From: Amanda Scholes on behalf of Planning.Responses
Sent: 17 November 2020 11:05
To: Planning Scanning
Subject: FW: Y/94/20/DOC, kiosk &

This is not a further information which we are asking for but the requirement of condition 9 that you want to discharge.

Subject: Y/94/20/DOC, kiosk &

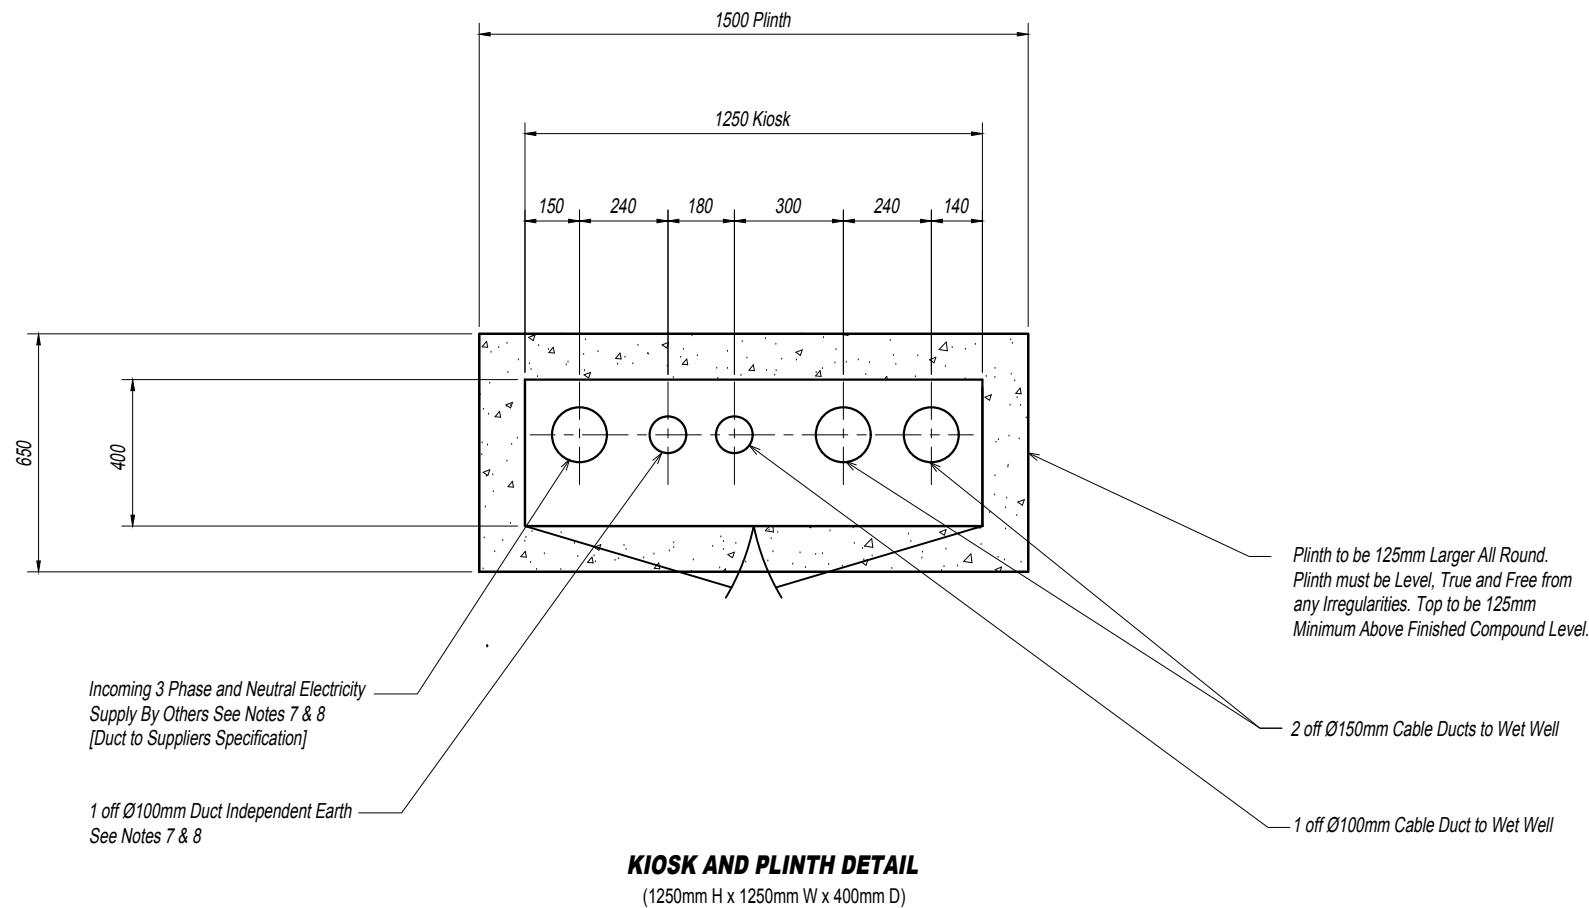
Is it the kiosk alone which will be over the ground?
No fence?

Correct

CINDERS NURSERY
PUMPING STATION KIOSK

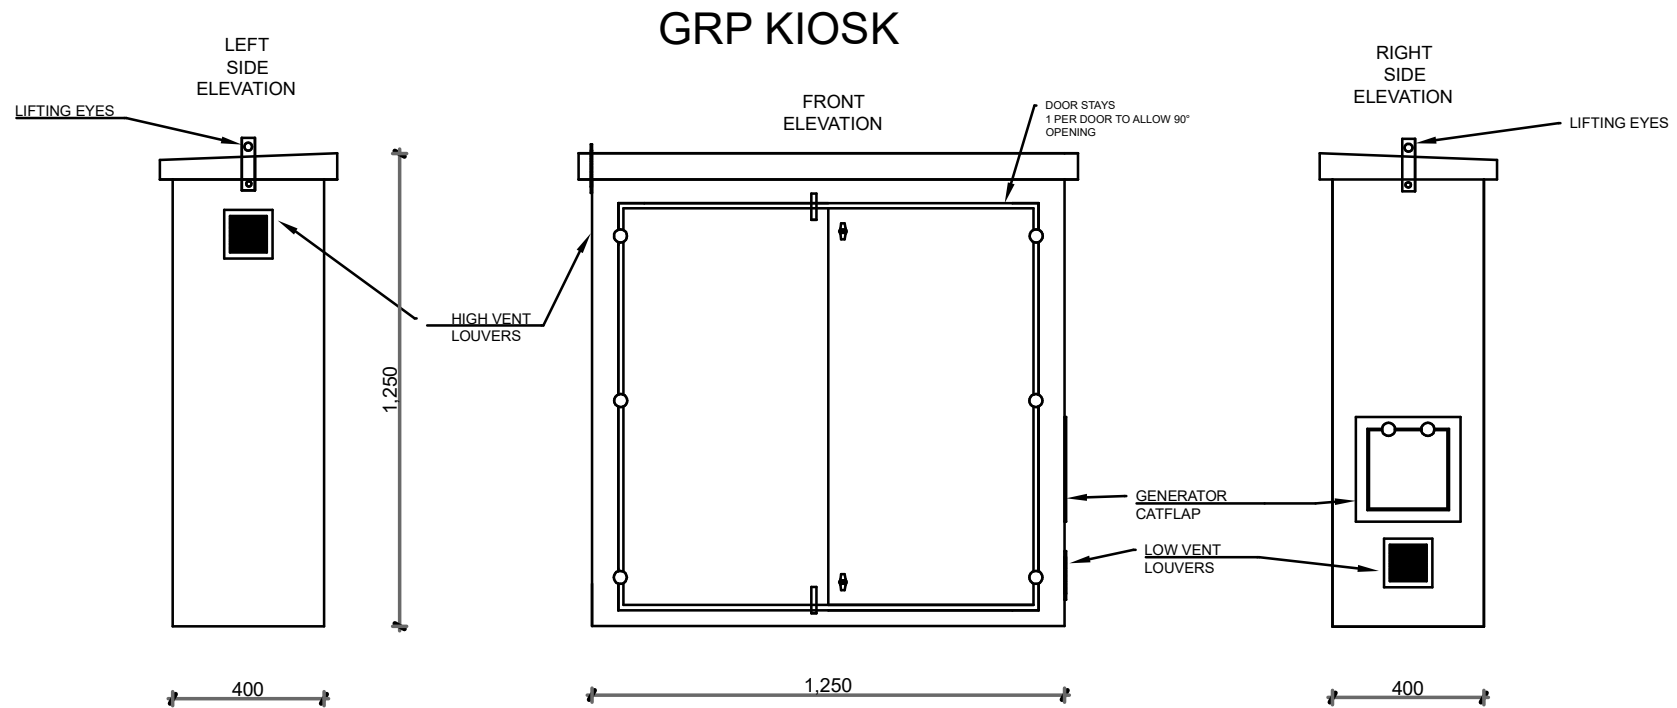
Are you providing us with elevations.

Drawing attached
